# **GATWICK AIRPORT NORTHERN RUNWAY PROJECT**

### **Comments on The Applicant's Response To The ExA's Written Questions (ExQ1)**

#### **Response to [\[REP3-096\]](#) | Land Use and Recreation**

**DEADLINE 4: 15 May 2024**

DRAWING TITLE
Museum field
Sketch Landscape Concept

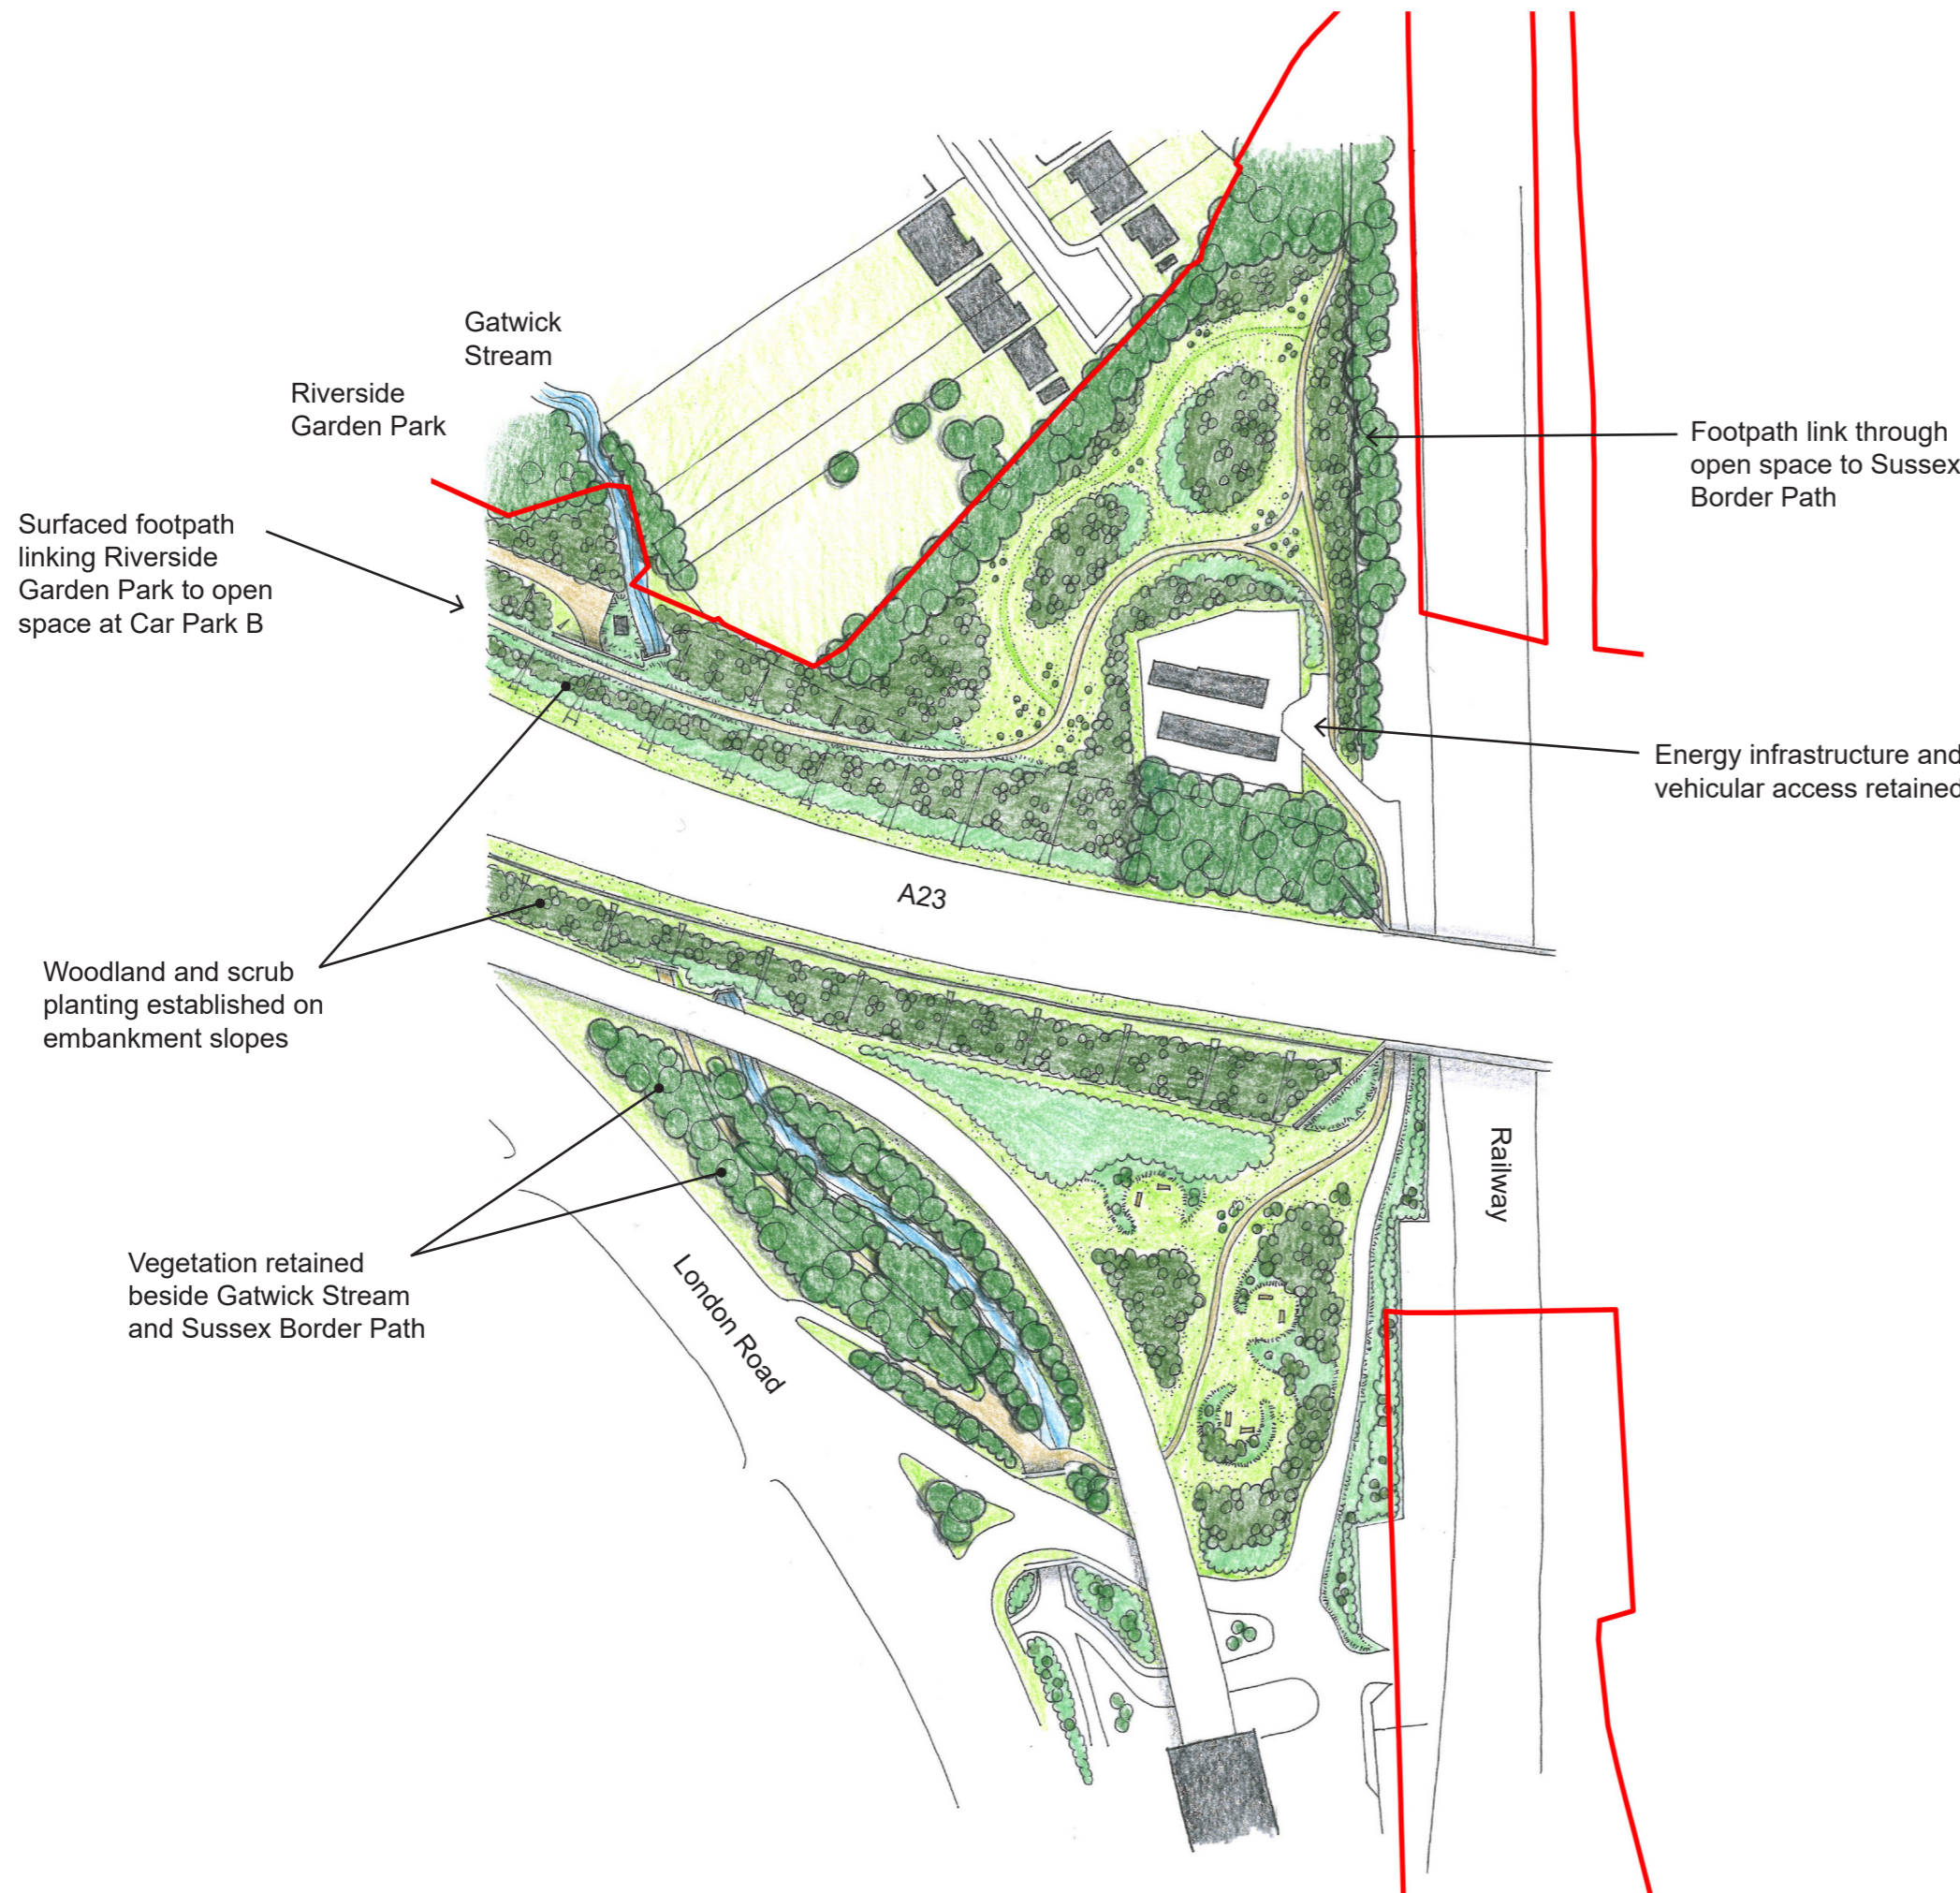
ExQ1	Question to:	Question and Applicant’s Response	Legal Partnership Authority’s Response
<b>LAND USE AND RECREATION</b>			
LU.1.13	The Applicant	<p><b>Museum Field – Informal Recreational Space</b></p> <p>Concern has been raised in Table 11.1 of the Joint West Sussex LIR that the new route would be relatively inaccessible as access would be via an indirect permissive route and the remote location of the space would have poor links to existing Public Rights of Way (PRoW). This would therefore result in a barrier to effective use by the nearby community [REP1-068]. Please provide comment in respect of this concern and confirm whether improved connectivity could be achieved?</p> <p>The land to the west of the River Mole including Museum Field is proposed as an area of ecological and landscape mitigation. The outline designs for the area include informal public access to this area through a new link from the existing permissive footpath route along the River Mole. The commitment to the provision of this footpath route is included at paragraph 4.4.2 of the <b>OLEMP</b> [[REP2-021]. This ecological and landscape mitigation area is not being proposed to be provided as a designated area of open space. Designated areas of open space are proposed in areas adjacent to the Church Meadows</p>	<p>The Authorities remain concern about the connectivity of this area via a permissive path to the wider footpath network as based on the limited detail provided in the Sketch Landscape Concept (Figure 1.2.1 of the OLEMP) [REP3-031], the drawing does not show a footpath connection along the western bank of the River Mole on land within the DCO Limits. This is also unclear from the works plans drawing GA 990002 Rev P03 [REP3-011] and it is noted that the permissive paths are also excluded from figure 19.6.4 in the ES Chapter 19 [APP-058].</p> <p>The Authorities still consider that a link into the Museum Field would be beneficial from Horley Road notwithstanding there is not footpath along the southern side of the road to provide an alternative route to any permissive path as the routes along the River Mole including the adopted rights-of-way are very wet and at times are impassable.</p>

<p>and within Car Park B, north and south.</p> <p>The current permissive route located on the western bank of the River Mole acts as a rural footpath to walk south along the river and is used regularly by walkers and dog walkers who enjoy views across the River Mole and the wider Gatwick airfield. Access to this route can be gained from the Sussex Border Path which also runs along the western bank of the River Mole.</p> <p>The Applicant did review the possibility of providing a pedestrian access to the north western part of the ecological area which borders the Horley Road from the pavement footpath which connects to Charlwood Village. However, the winding nature of the road compromises sight lines in this location and, together with the proximity to the change in speed limit, does not make for a safe pedestrian crossing either where the paved path currently terminates or indeed to either side of this location. In order to create a safe and compliant crossing with good sight lines, it is likely that removal and re-alignment to portions of existing hedgerows and movement of utility poles would be required. A bridge would also be required across the highways ditch on the south side of the road. The location of the 30mph speed limits might also have to be moved further east towards Brook Farm. The Applicant also considered that an unintended consequence of providing the connection could be that people wanting to access the area would park their cars on the</p>

pavement or soft verge, which would again be undesirable, reduce amenity to existing residents, affect access to their driveways, and overall be unsafe.	
--	--	--	--
